Application for a Non-Material Amendment Following a Grant of Planning Permission

ERECTION OF SINGLE STOREY REAR & SIDE EXTENSION FOLLOWING DEMOLITION OF EXISTING DETACHED GARAGE

FG/92/21/HH

FLAT ROOF TO REPLACE FLAT ROOF WITH SMALL PITCHED ROOF AROUND THREE SIDES

ARW Design	DRAWING TITLE: BLOCK PLAN PROJECT: SINGLE STOREY REAR EXTENSION & GARAGE TO SIDE ELEVATION	LOCATION: 22, ONSLOW DRIVE, FERRING CLIENT: S. HARRIS	SCALE: AS NOTED @ paper size A3 DATE: MARCH 2021 DRAWN: ARW	DRAWING NO: 5087/6 REVISION: a
------------	--	---	---	--

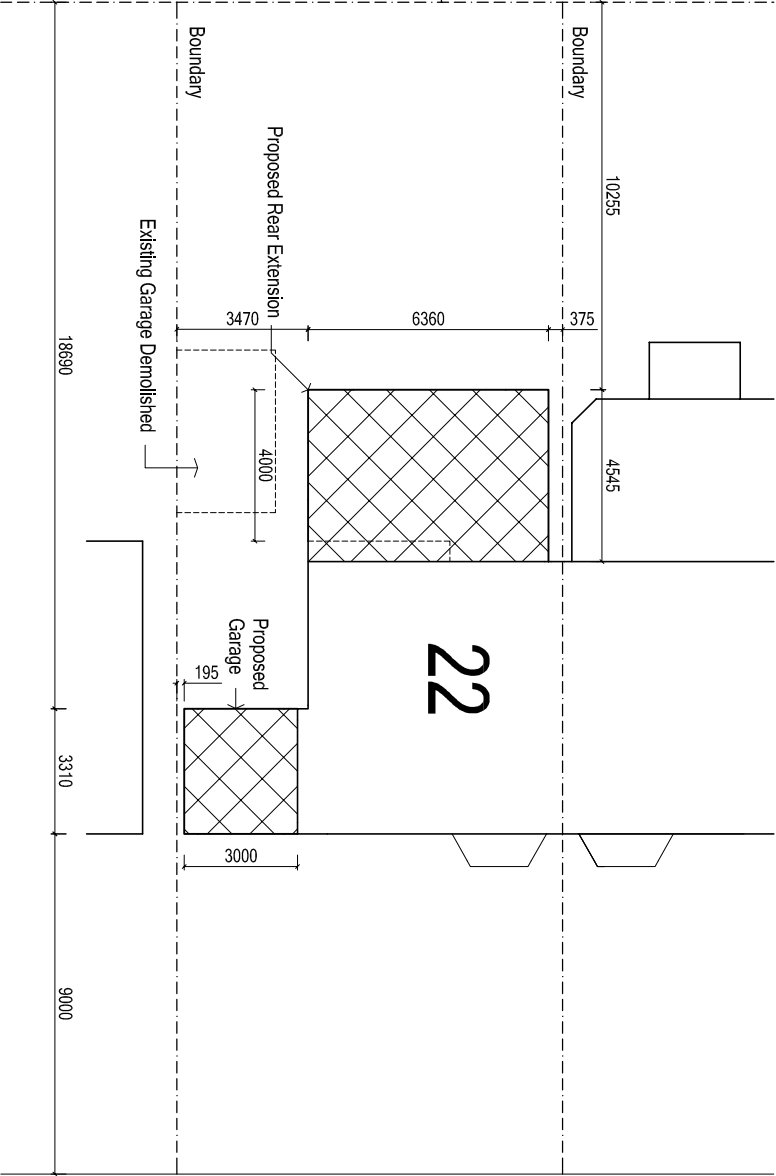
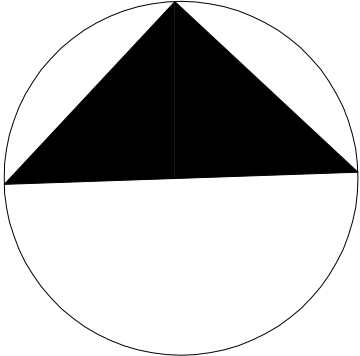
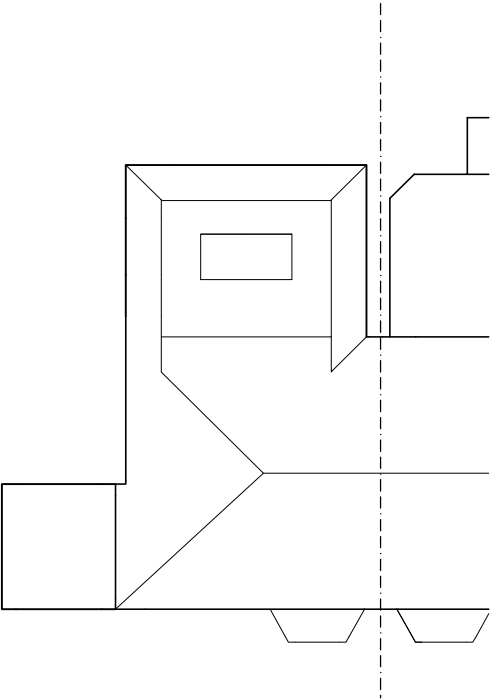
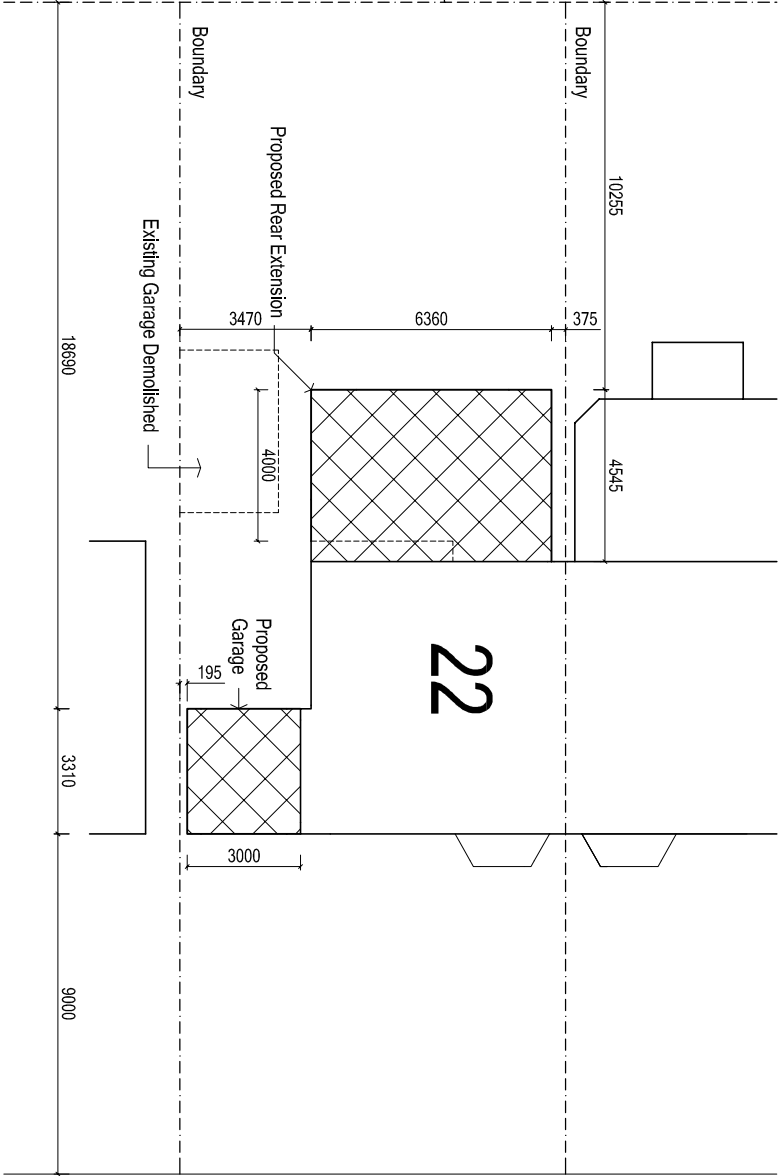
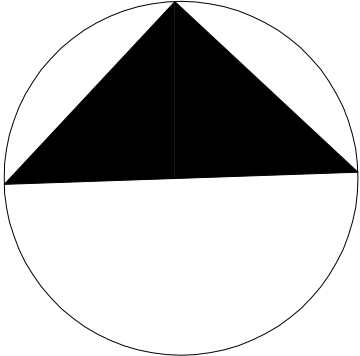
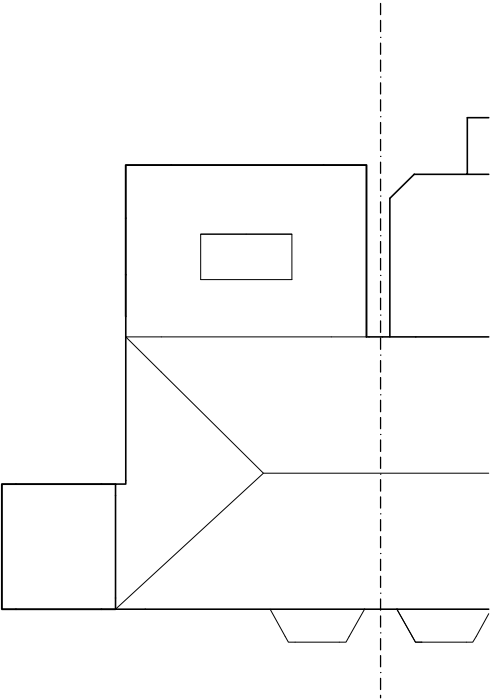
ELEVATIONS 5087/1 SECTION 5087/7 BLOCK PLAN 5087/6

ELEVATIONS 5087/1 Rev a SECTION 5087/7 Rev a BLOCK PLAN 5087/6 Rev a
